From: Brenda Larsen
Sent: Monday, September 23, 2013 8:24 AM
To: Jeff Watson
Subject: RE: BL-13-00023 Haw

Re: Haw (BL-13-00023)

INCREASE SIZE OF LOT -0602 BY
BOUNDARY LINE ADJUSTMENT WITH LOT
-0603 AS INDICATED BY CLOUDED AREA

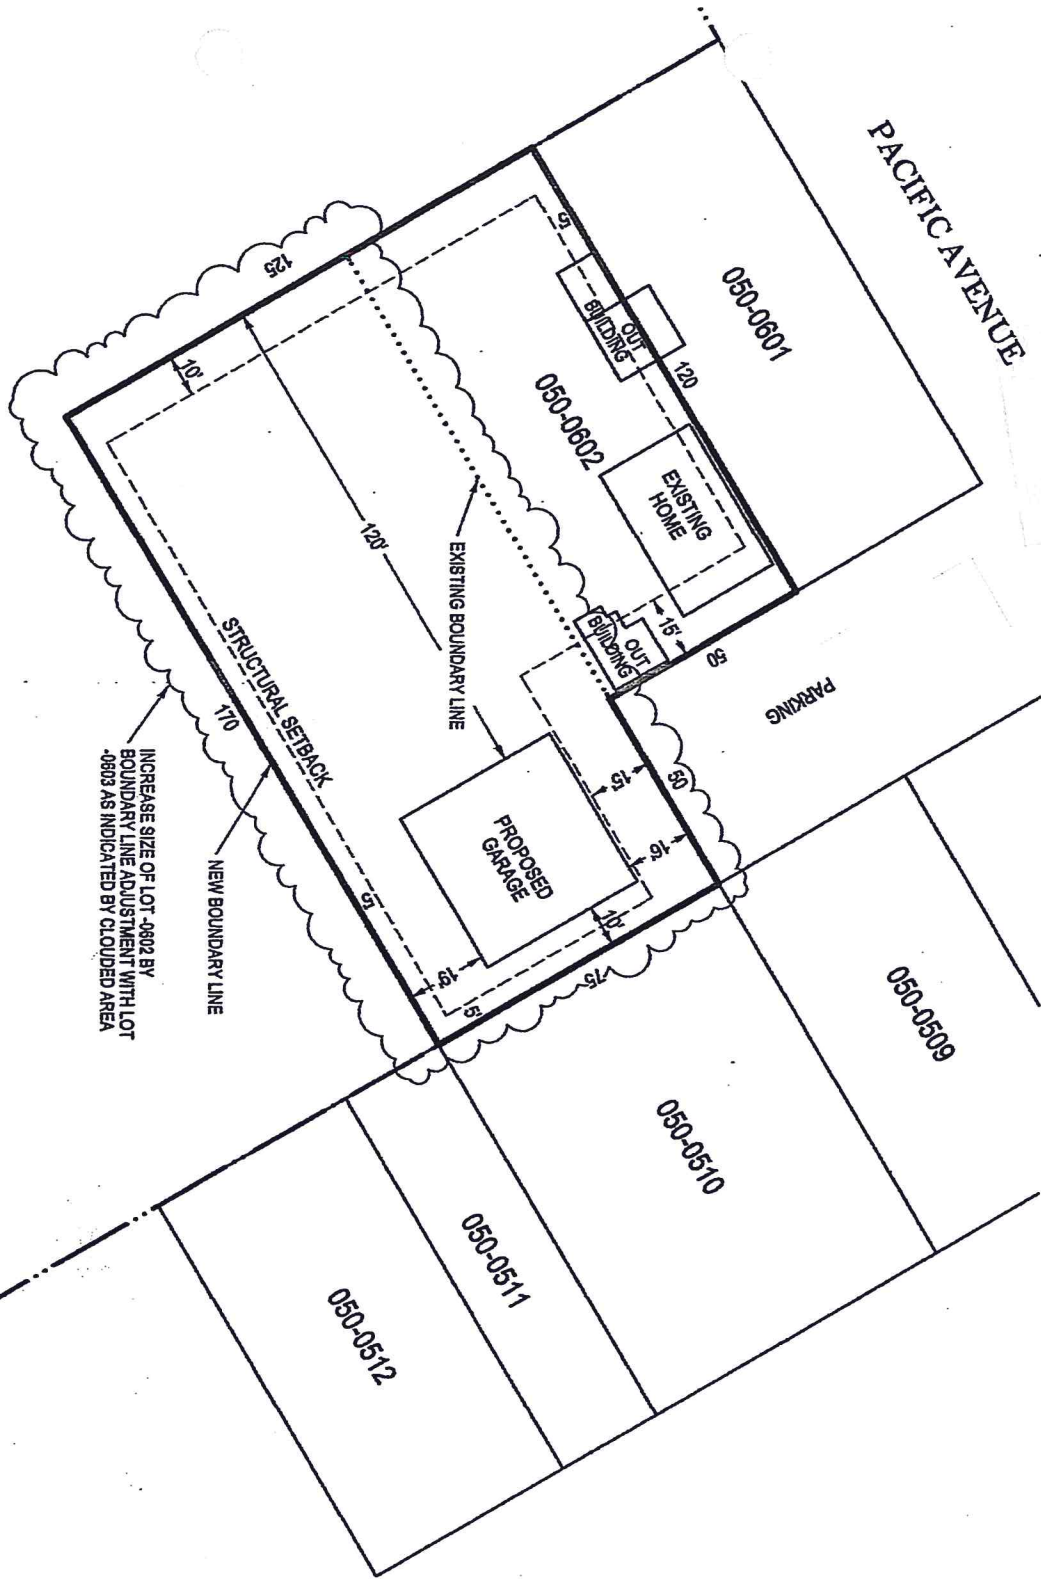
- Ensure that boundary line adjustments do not infringe upon existing structures, to include propane tanks, etc.
- Ensure adequate access for fire apparatus. Any driveways or access points created based off the new lot configurations shall comply with Kittitas County Code 20.02.030.
- All future development must comply with the International Fire Code.
